**Proposed front dormers**  
**2 Barrack Lane Aldwick**

**Our Ref: AW/292/11/**  
**Your Ref:**

**Please ask for:**  
Mrs D Johnson  
(01903) 737500 Ext 37762  
22nd November 2011

Drawing Title
existing plans

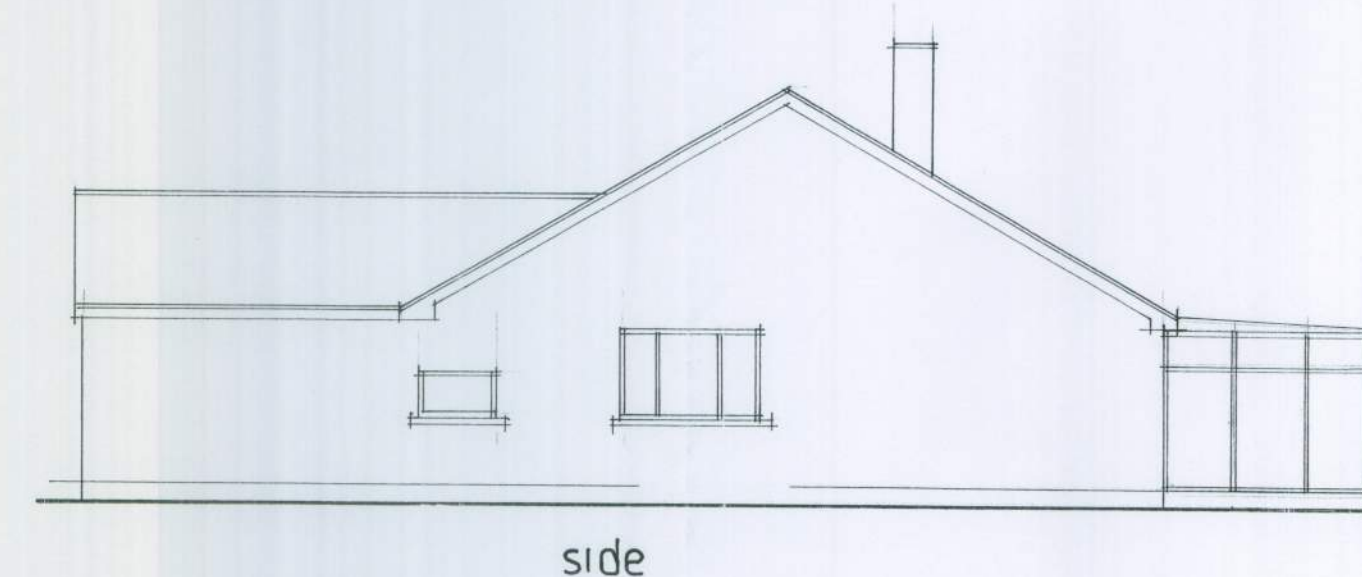
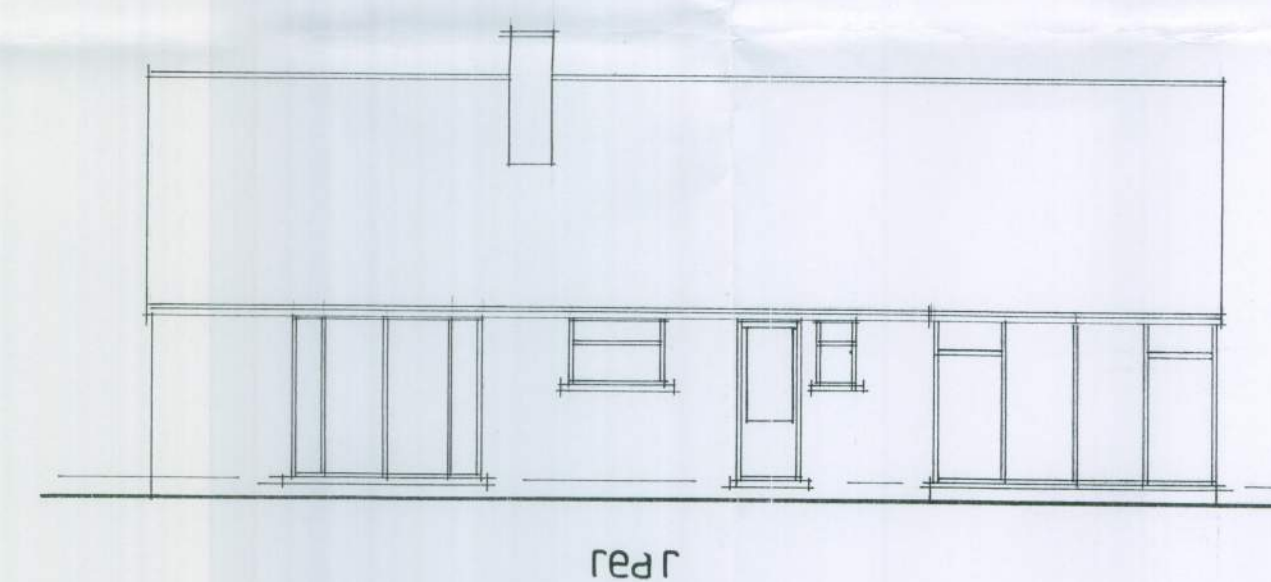
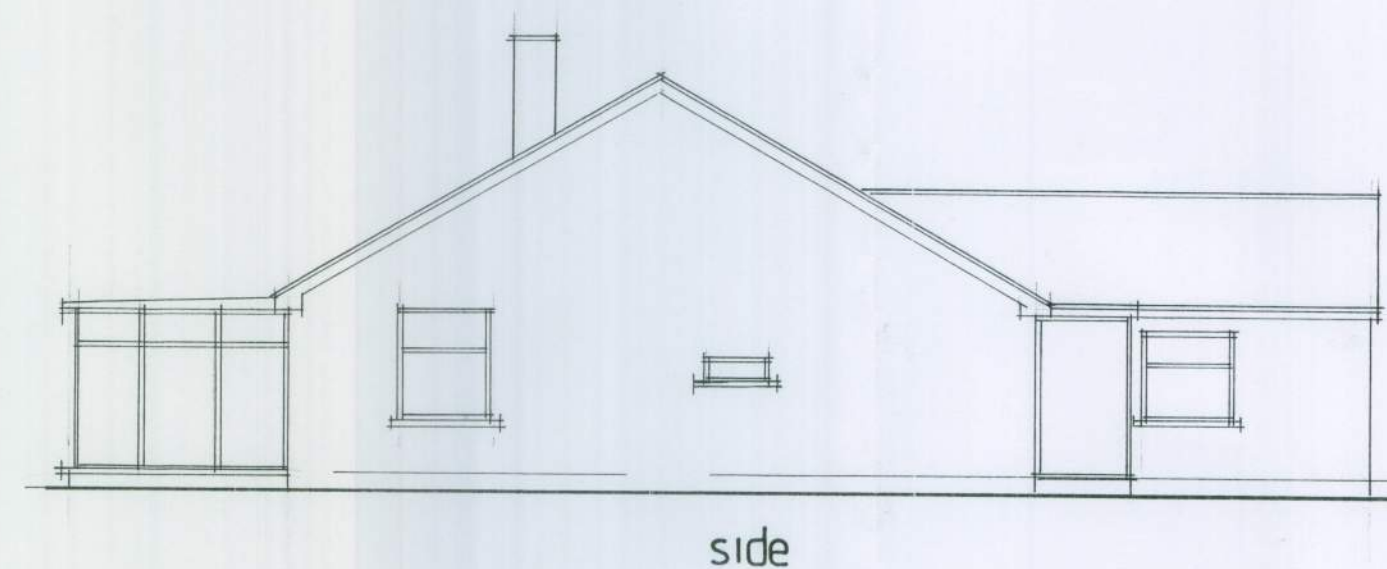
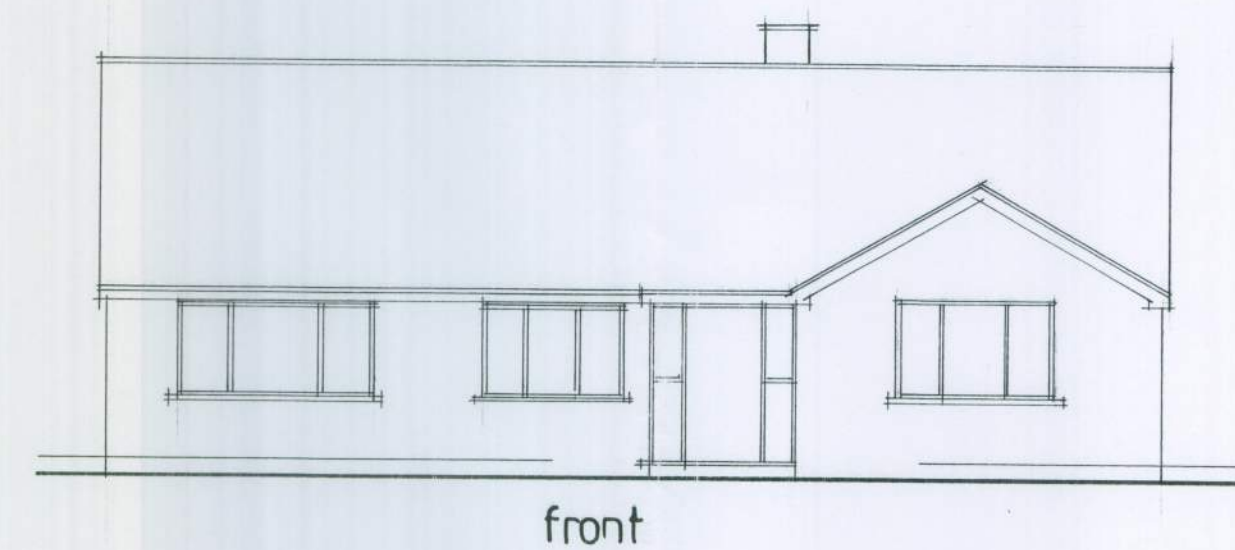
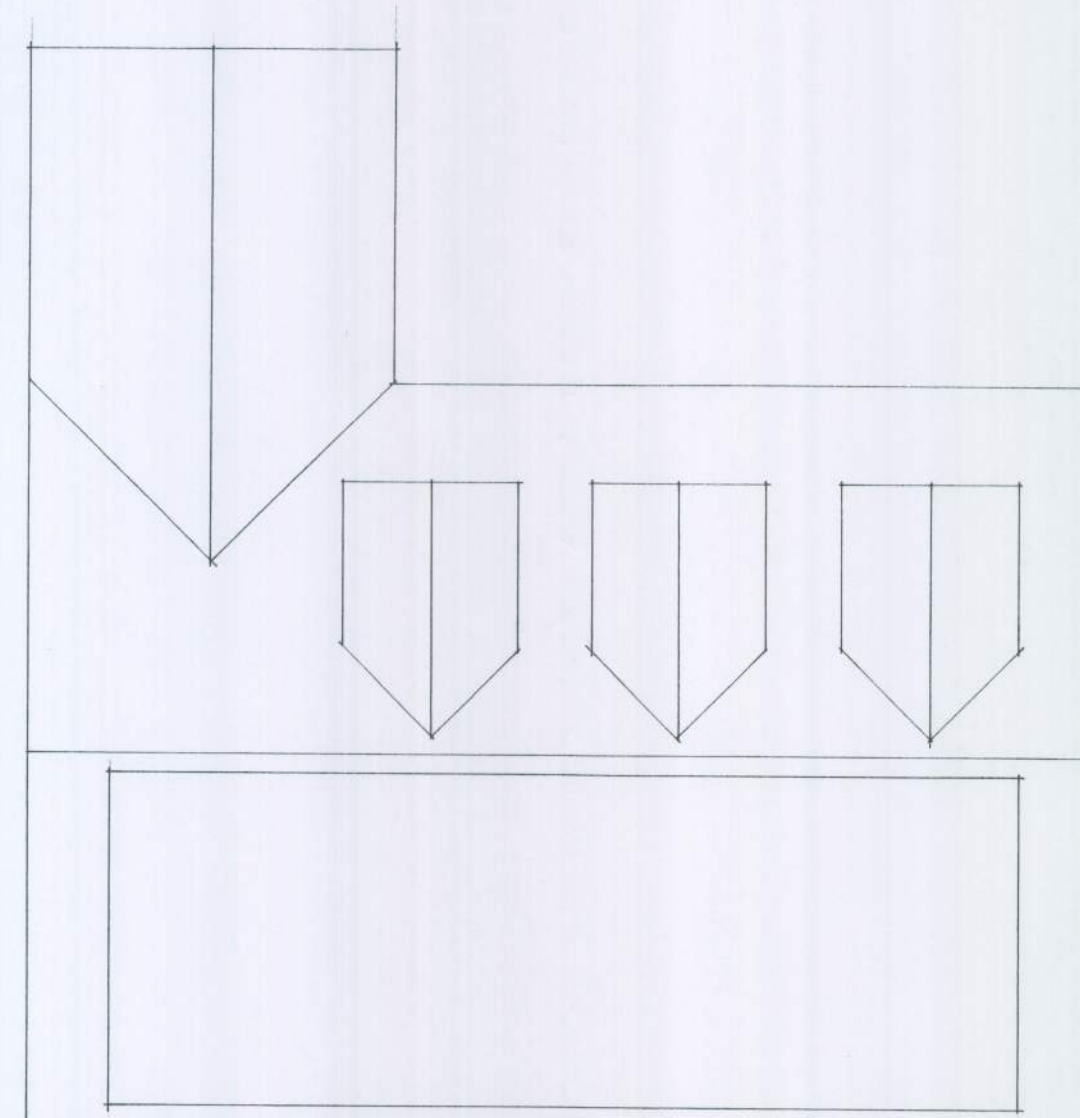
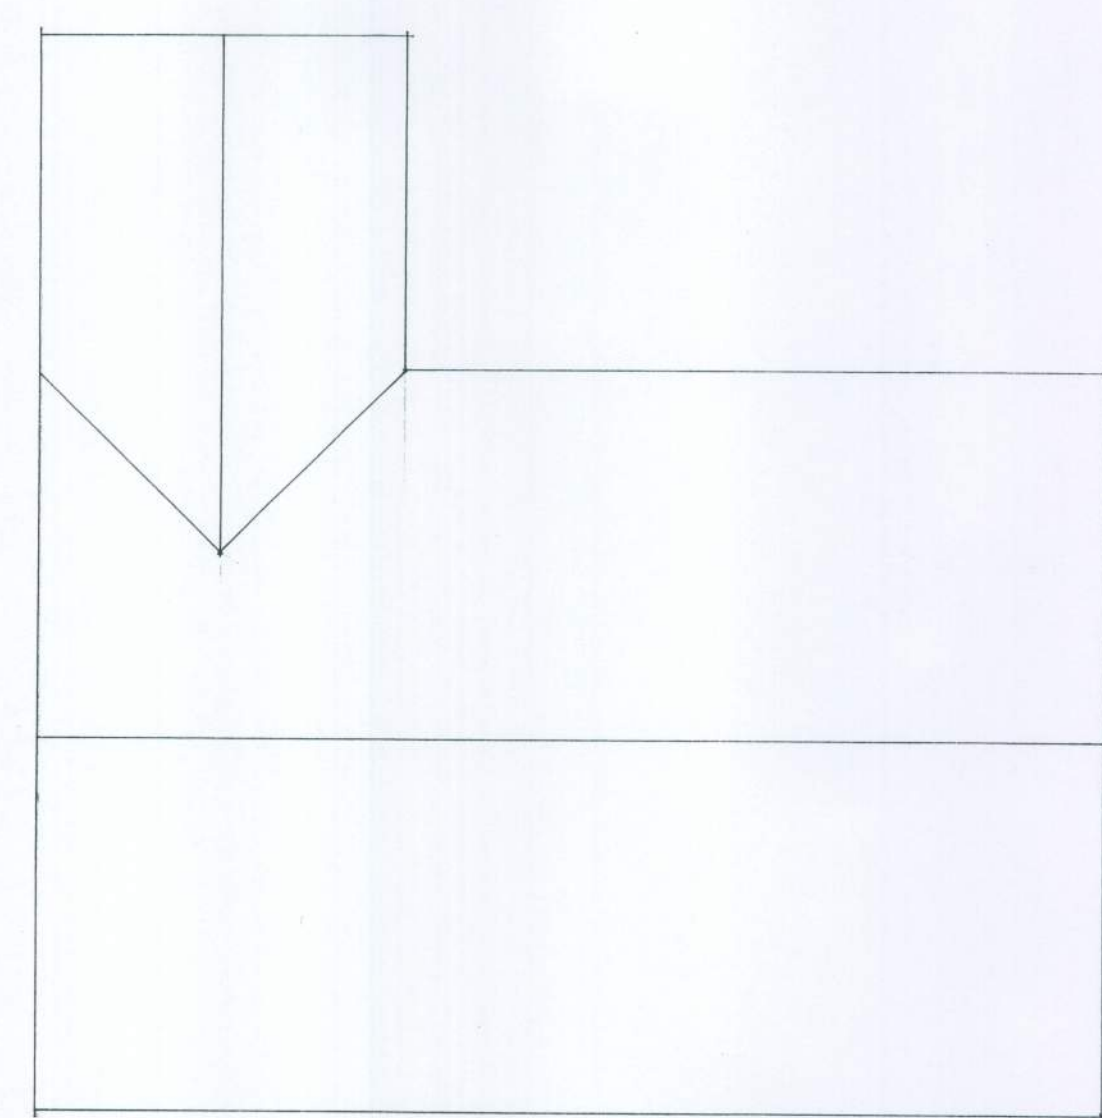
The existing side elevation does not accord with the existing side floor plan. Please amend accordingly.
